SUBMISSION TO EXAMINING AUTHORITY
On behalf of
GREENSFORGE SAILING CLUB

In respect of
Application for Development Consent Order for
West Midlands Interchange
By Four Ashes Ltd

2.6A

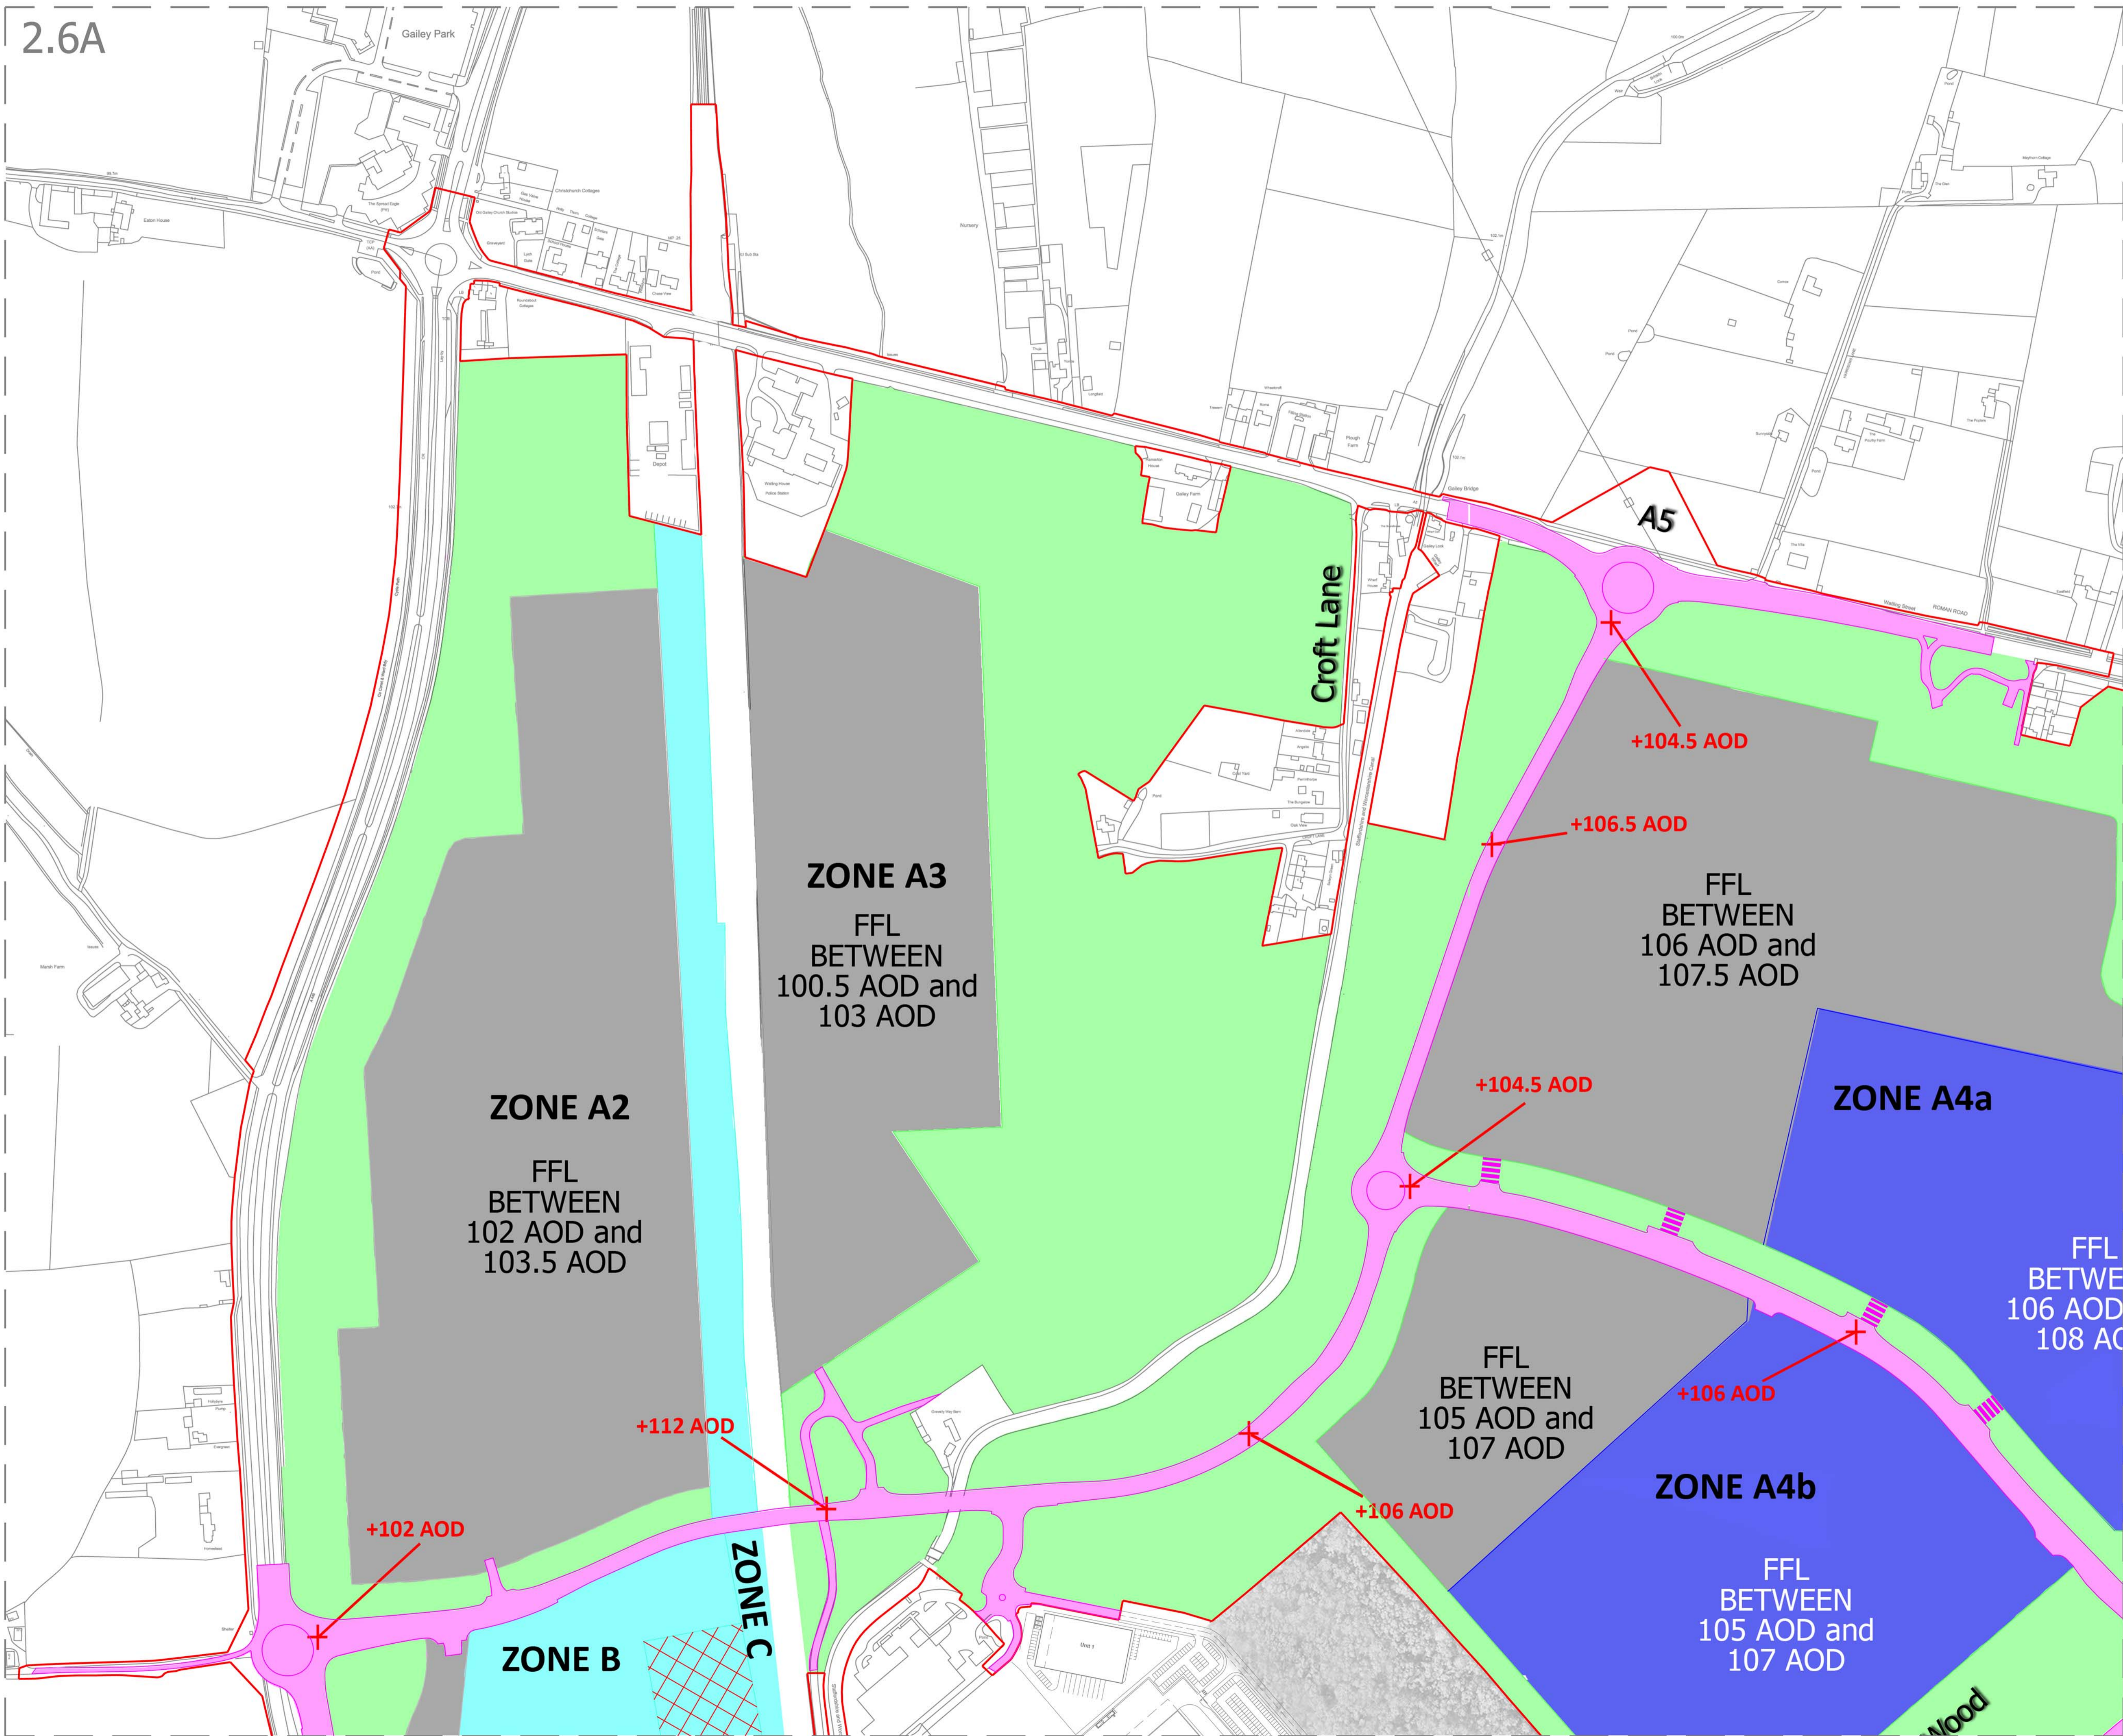
- 3.2 The Development Zone Parameters Plan (Doc 2.5) proposes a development block immediately to the south and west of the reservoir, with a suggested 2-6 warehouses comprising a total GEA of 50,835sq.m. contained within Zones A4a and A4b. Buildings heights are indicated on the Parameter Plan (Doc 2.6 Floor Level and Building Heights Parameters Plan) indicated as being between 20m and 30m high with a finished floor level of between 106AOD and 108AOD.

- 4.1 It is on the basis of the above that the Club request amendments to the Parameters Plan be made which restrict the height of buildings within Development Block A4a and A4b to ensure that sailing is not impeded by disturbed wind flow over buildings. It is noted that the minimum height of any building proposed on the site overall would be 12m which would still result in a minimum distance of 240m between the leeward face of any building and the reservoir being required to avoid any adverse impact upon sailing conditions.

- 4.2 Document 6.2 – Technical Appendix 14.1 – Wind Effects on Sailing (November 2017) concludes that sailing quality is likely to be reduced over the reservoir from the range of angles where the wind is predominant (broadly south-west to west). It suggests that these impacts can be minimised by minimising building height in these directions and that any intended landscaping is restricted. It is noted that the proposed landscaping bund and associated landscaping has not been amended or reduced as a result of this recommendation. However, as shown above it would also negatively impact on the sailing conditions on the reservoir, and consideration should also therefore be given to its total removal immediately adjacent the reservoir boundary.
